DRB CASE ACTION LOG (PREL & FINAL)

**August 18, 2004
DRB Comments**

PROJECT # 1003605

RE: Park Ridge, Lots 1 & 2, Block 4/minor plat

PLAT OF
LOT 1-A, BLOCK 4
RIDGE PARK SUBDIVISION

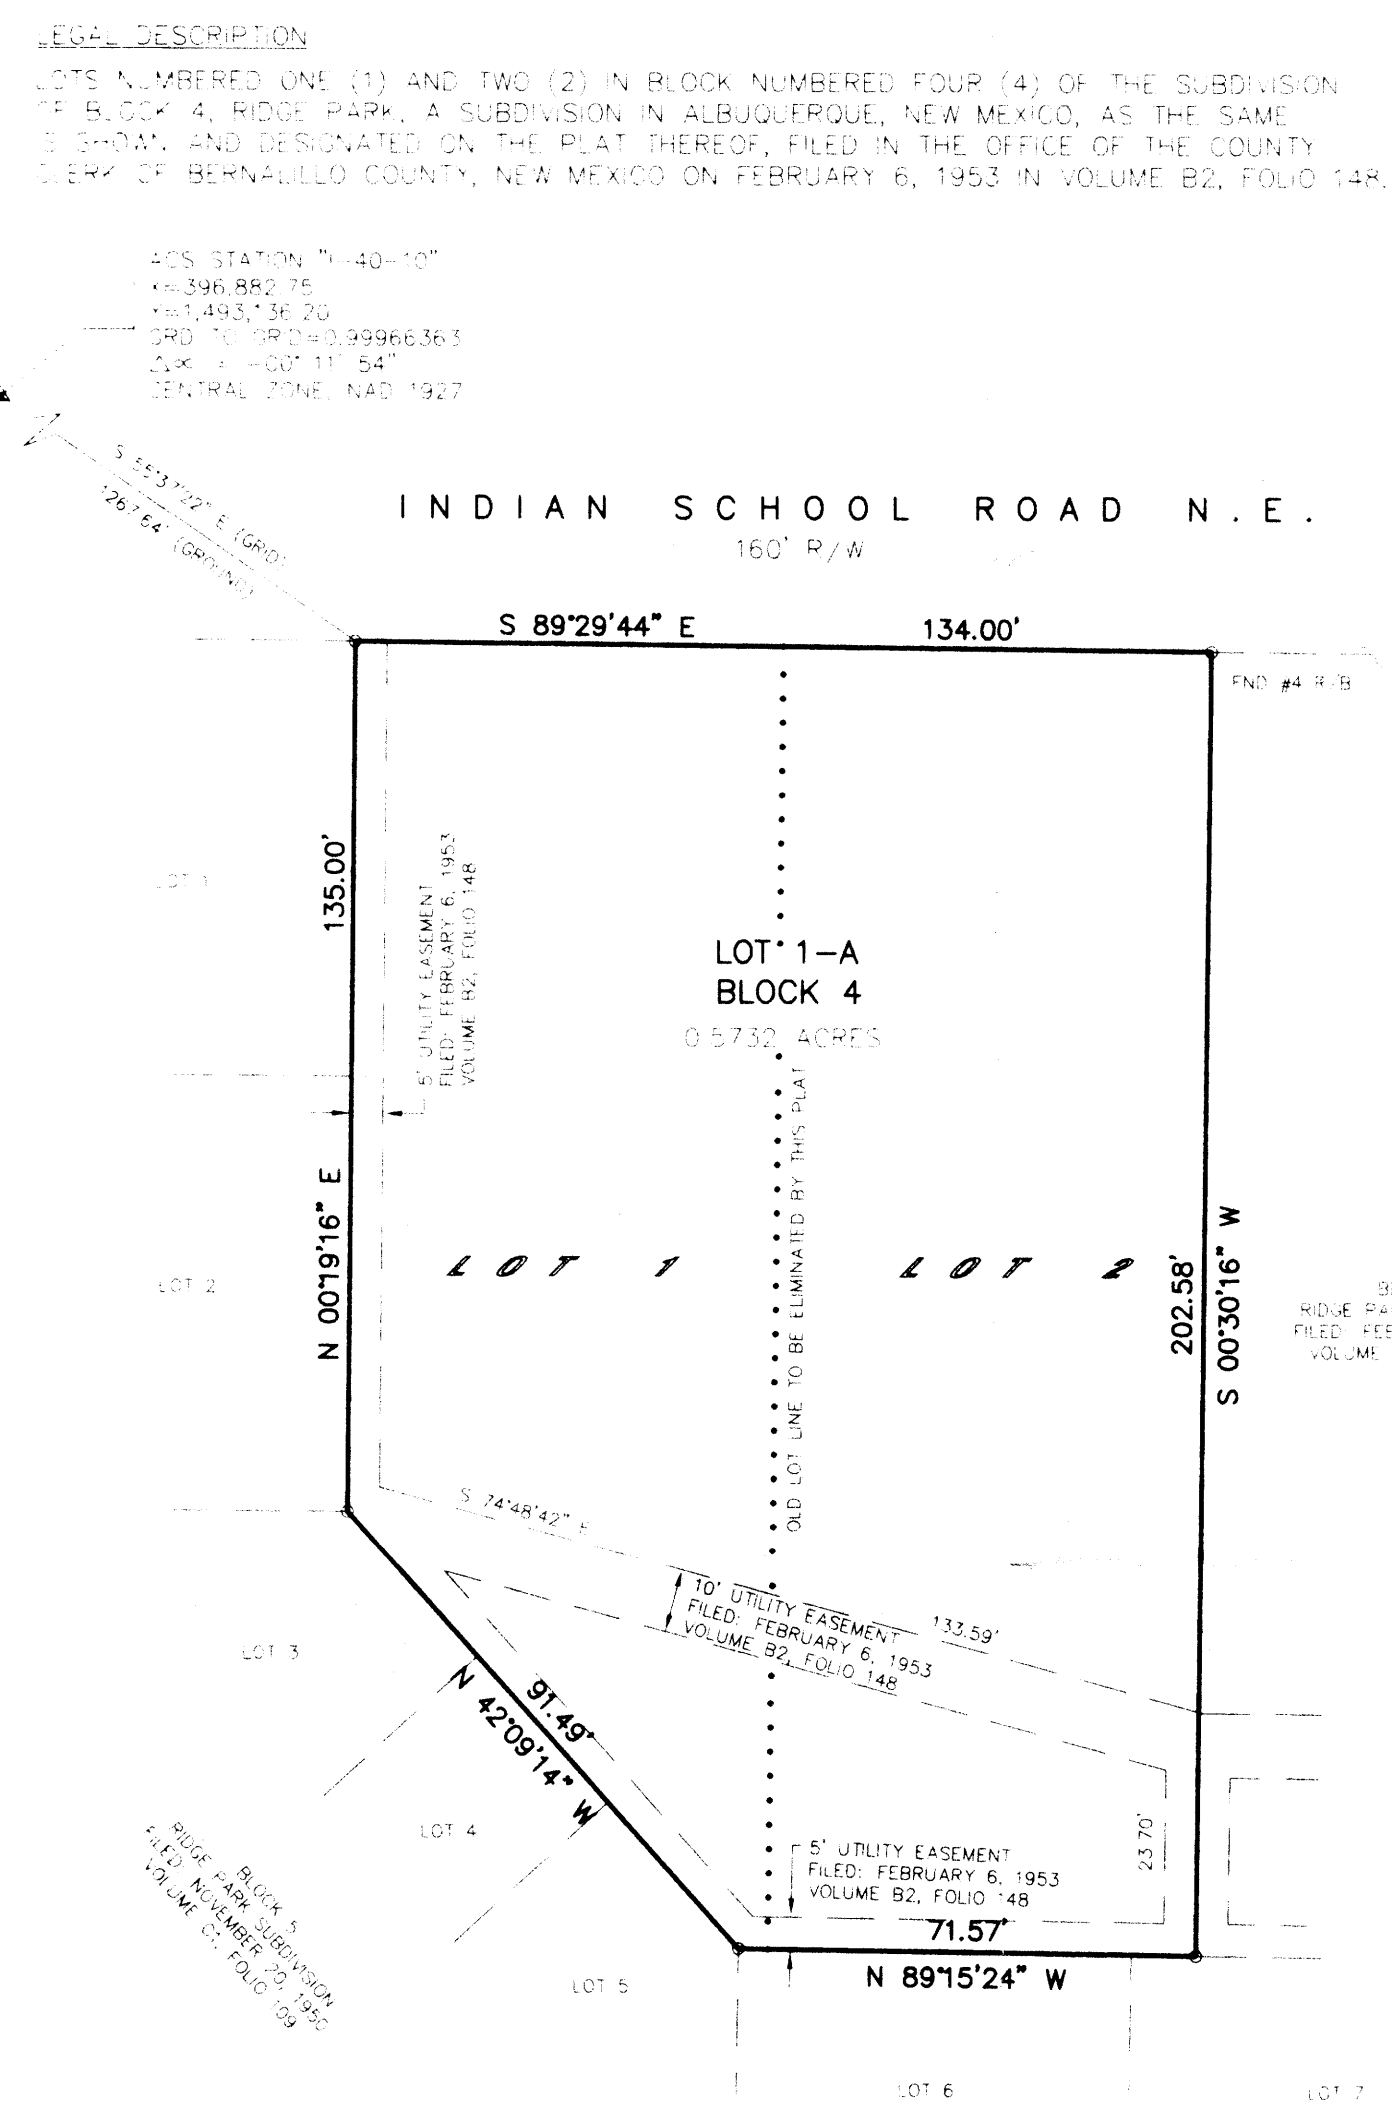
The current zoning should be listed on the plat.
